KITTITAS COUNTY

MEMORANDUM

TO: All Staff
FROM: Public Works Plan Review Team
DATE: May 19th, 2023
SUBJECT: BL-23-00007 Anderson

SHEET 1 OF 2

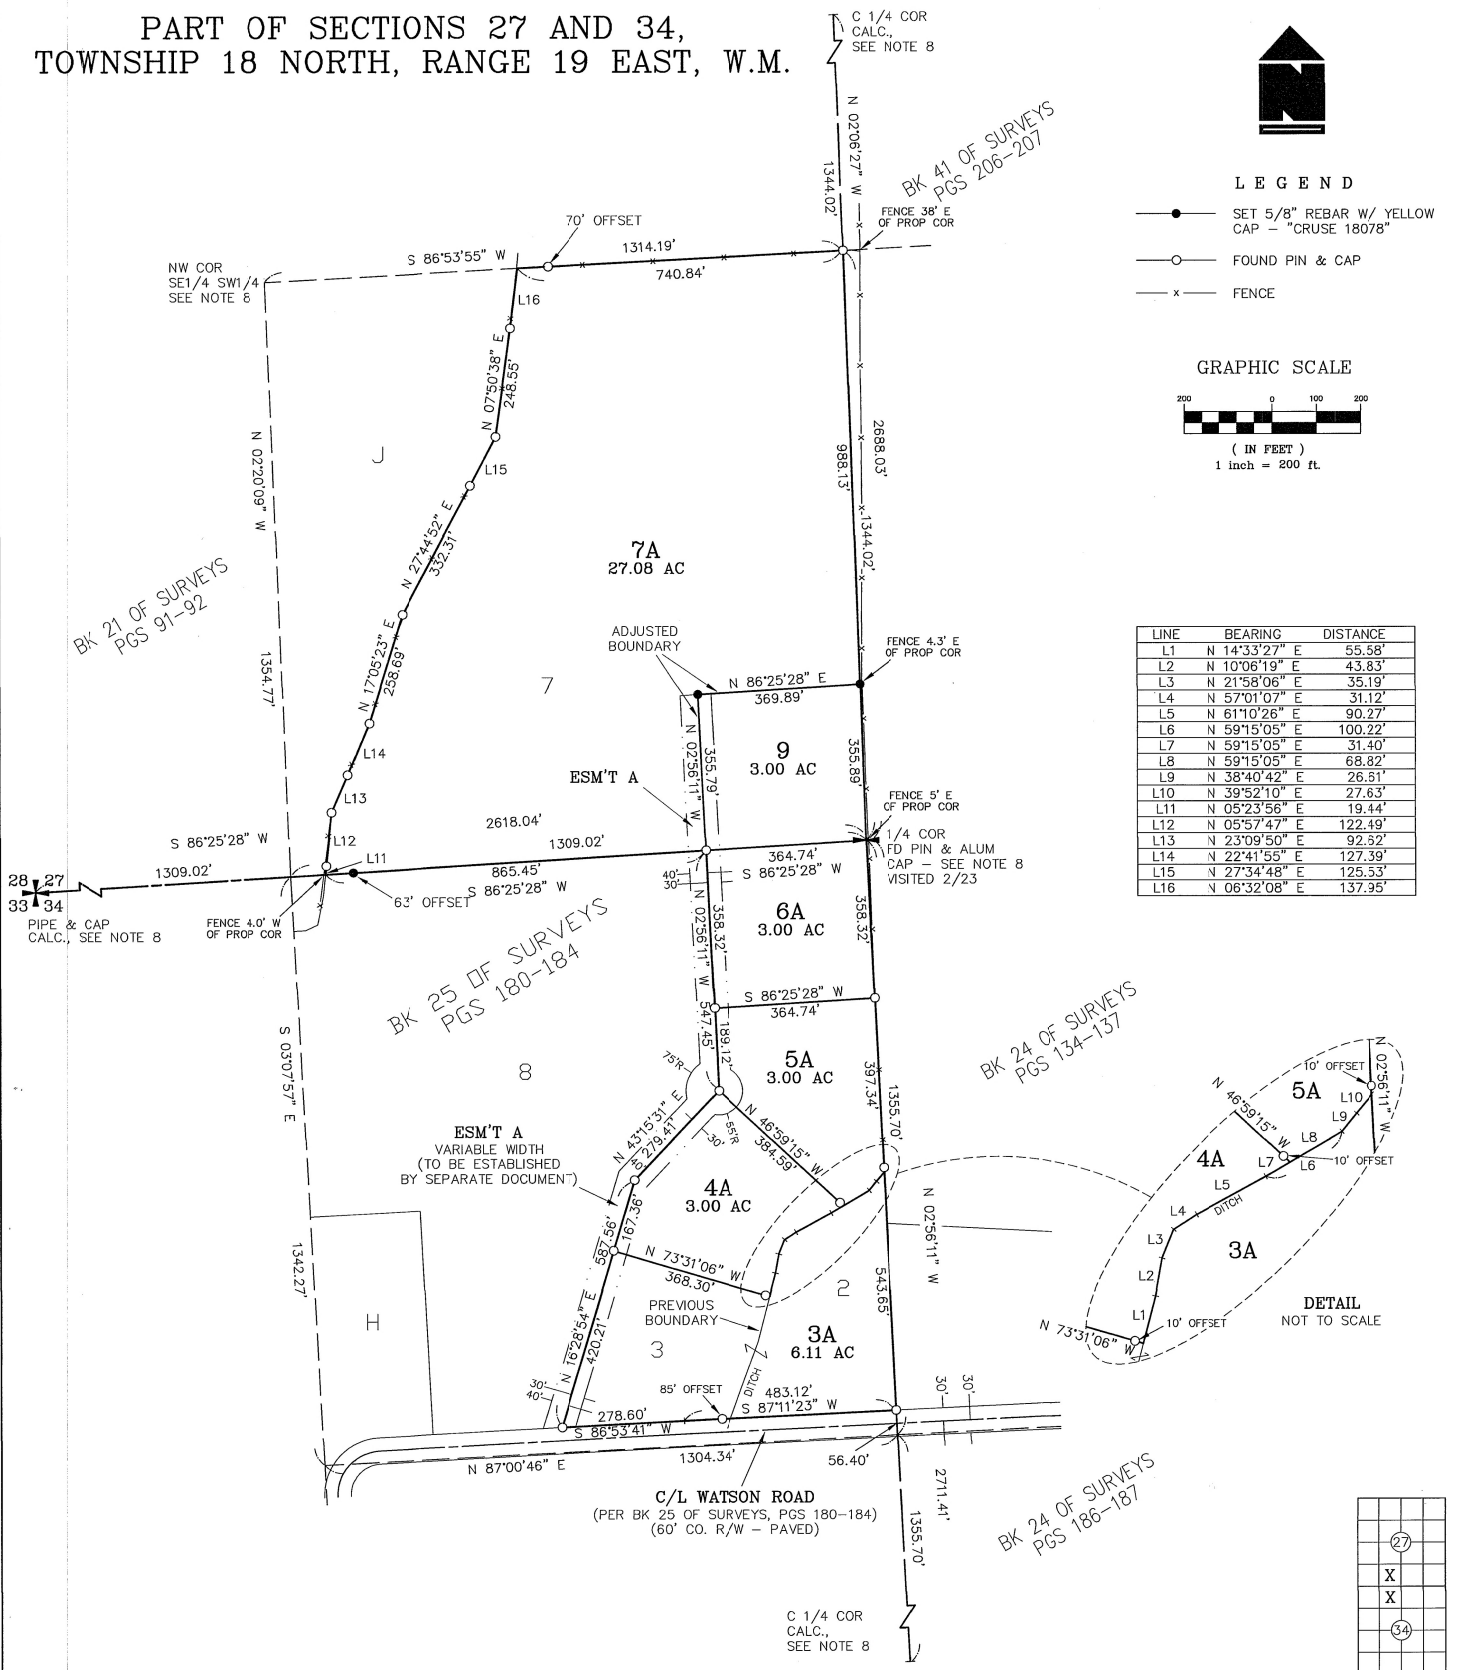
ENGINEERING	No Comments (CC)
SURVEY	<p>As a survey map was not included with the application, comments are reserved until final. (JT)</p> <p>7/10/23 review of survey submittal (kh)</p> <ol style="list-style-type: none"> 1. Property corners of Parcel 6A and 9 with section line, pin and cap are difficult to read. (RCW 58.09.050(4)) (WAC:32-130-050(1)(d)(i)) 2. Bearing is missing from southern boundary line of parcel 7A and 9
